**WEST SUSSEX COUNTY COUNCIL
STRATEGIC PLANNING CONSULTATION**

**SUBJECT: FG/84/15/PL - Temporary stationing of 1 No. residential caravan for 3 years
Eastlands, Littlehampton Road, Ferring, West Sussex, BN12 6PB**

Block Plan. Scale 1:500

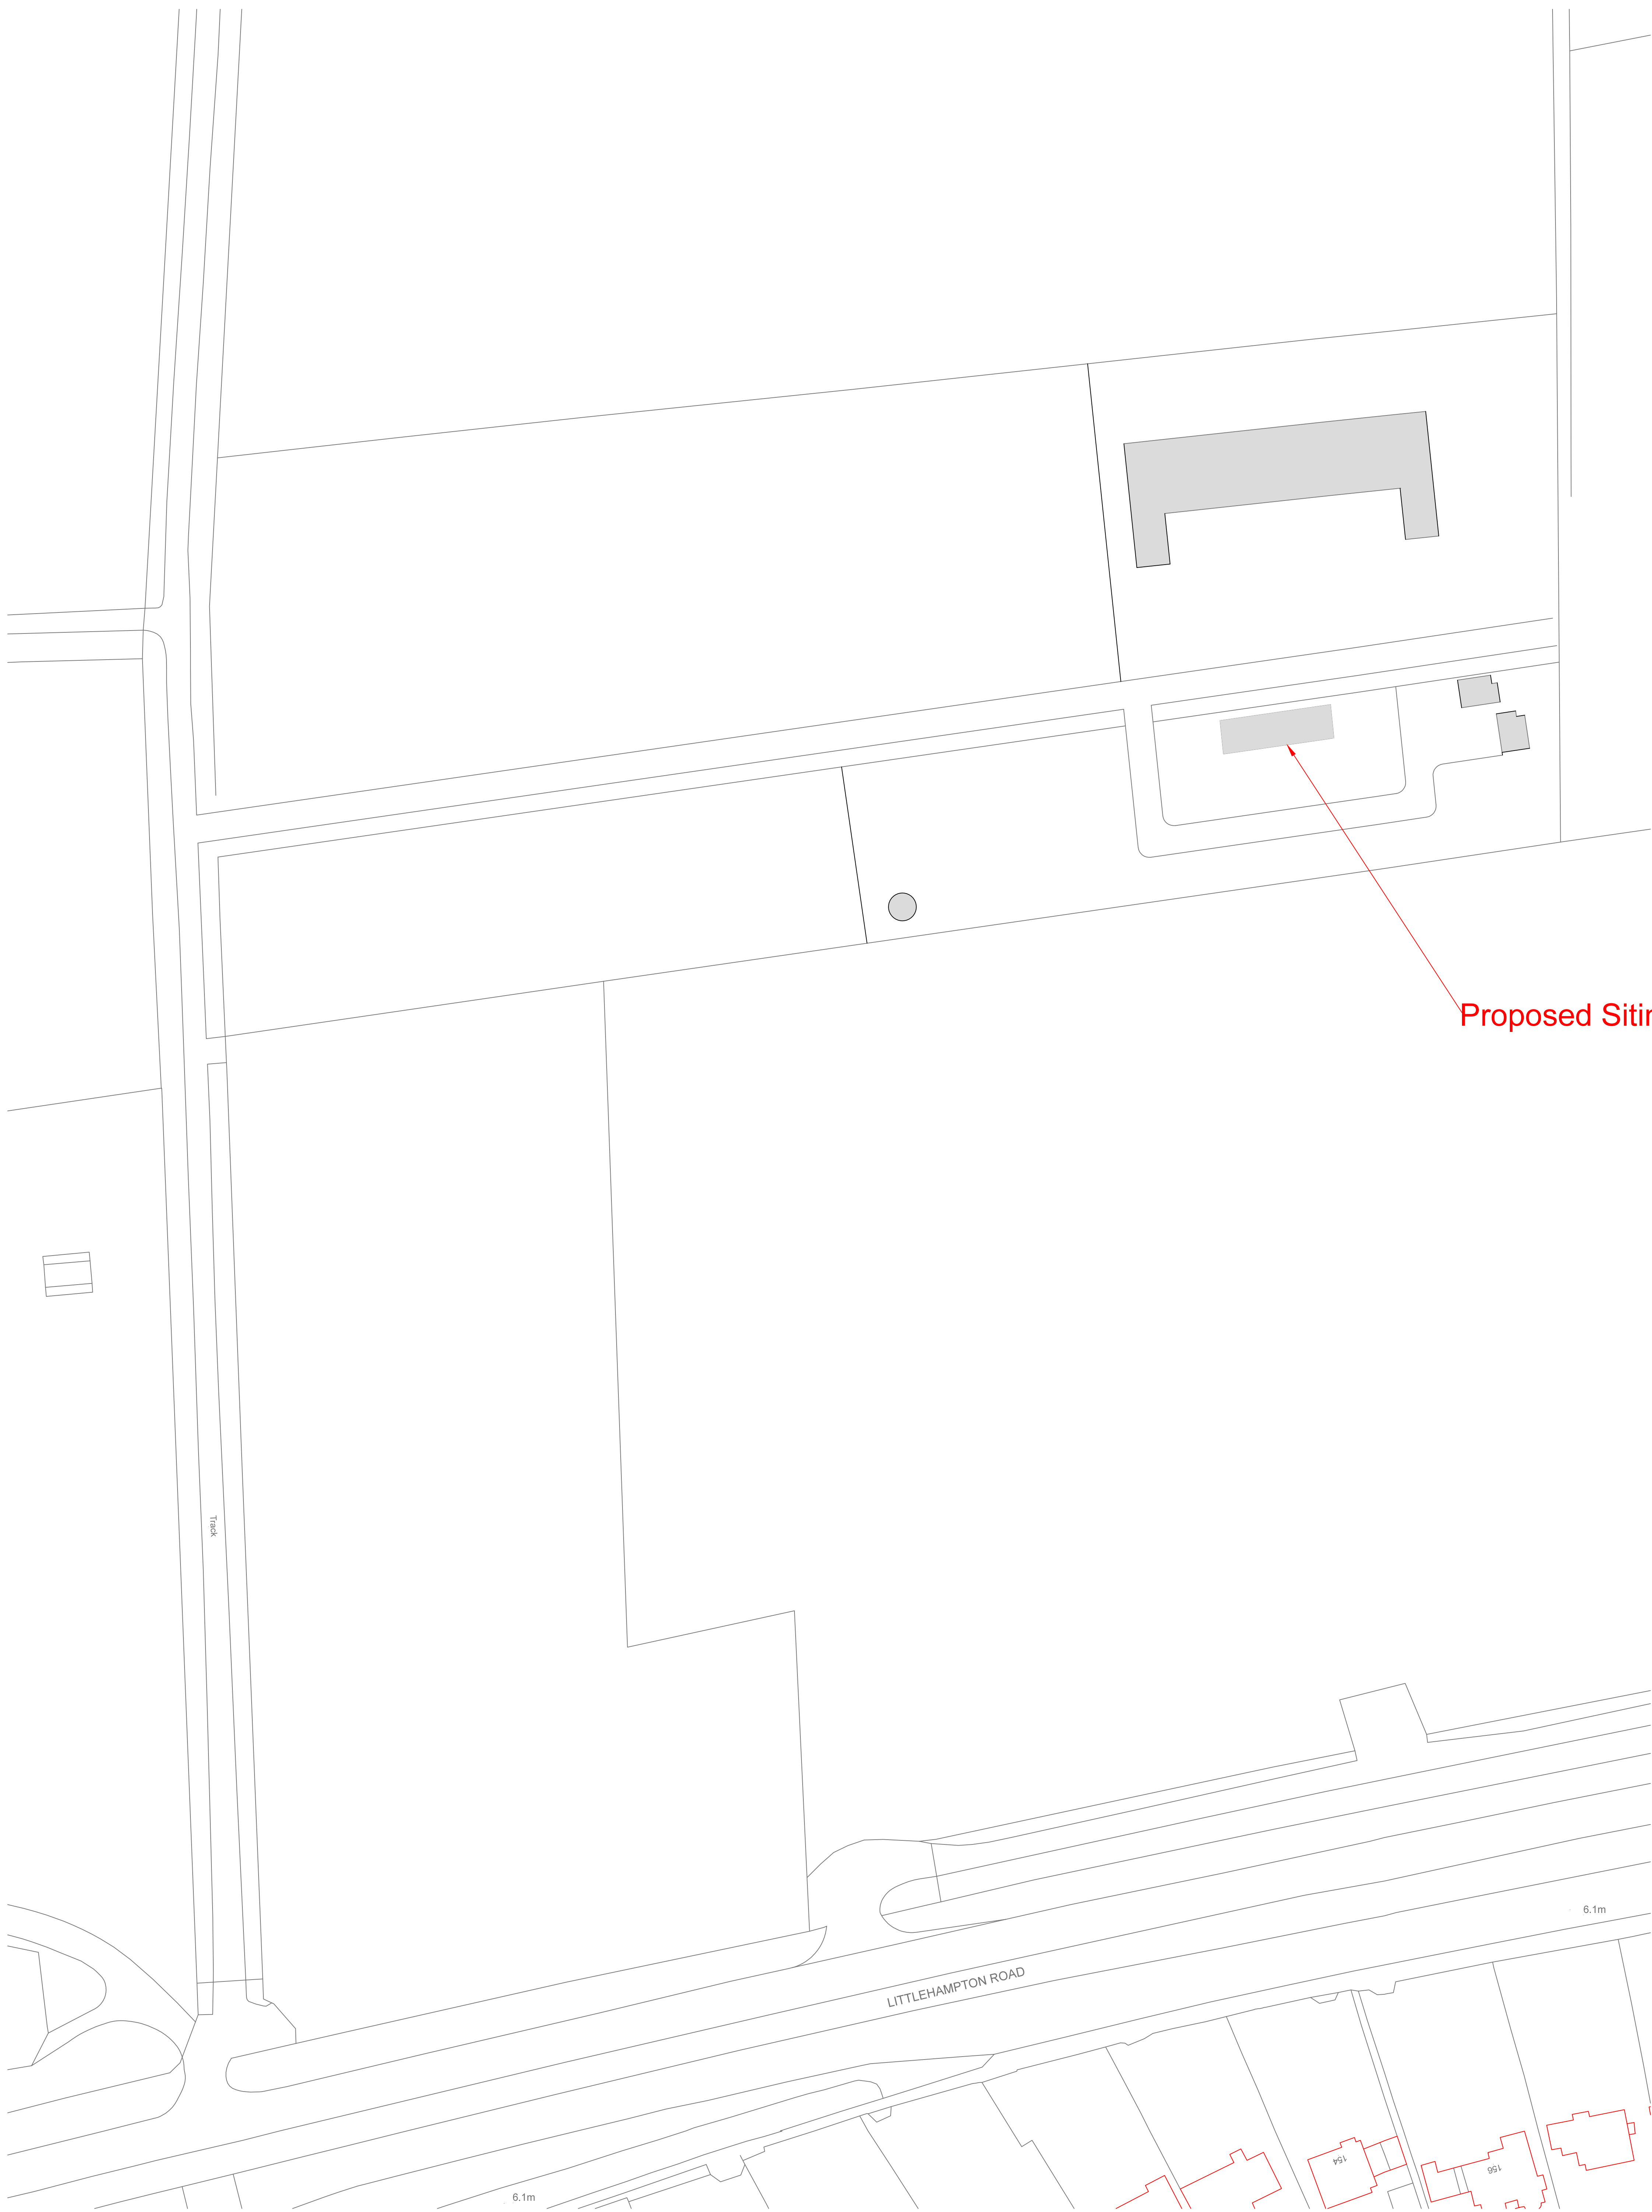
The proposal is for the siting of temporary residential caravan unit with access onto Littlehampton Road via an existing access point. From an inspection of the plans alone, there is no apparent visibility issue at the point of access onto Littlehampton Road. The most recently available verified accident records reveal there have been no personal injury accidents in the vicinity of the existing point of access, indicating a low risk of highway safety issues with this proposal.

The application site is not especially sustainable as it located off of a busy dual carriageway, with a lack of metalled footways or cycle ways in the vicinity. This would mean that a large number of movements from the site will be reliant on the motor vehicle

No part of the development shall be first occupied until covered and secure cycle parking spaces have been provided in accordance with plans and details submitted to and approved by the Local Planning Authority.
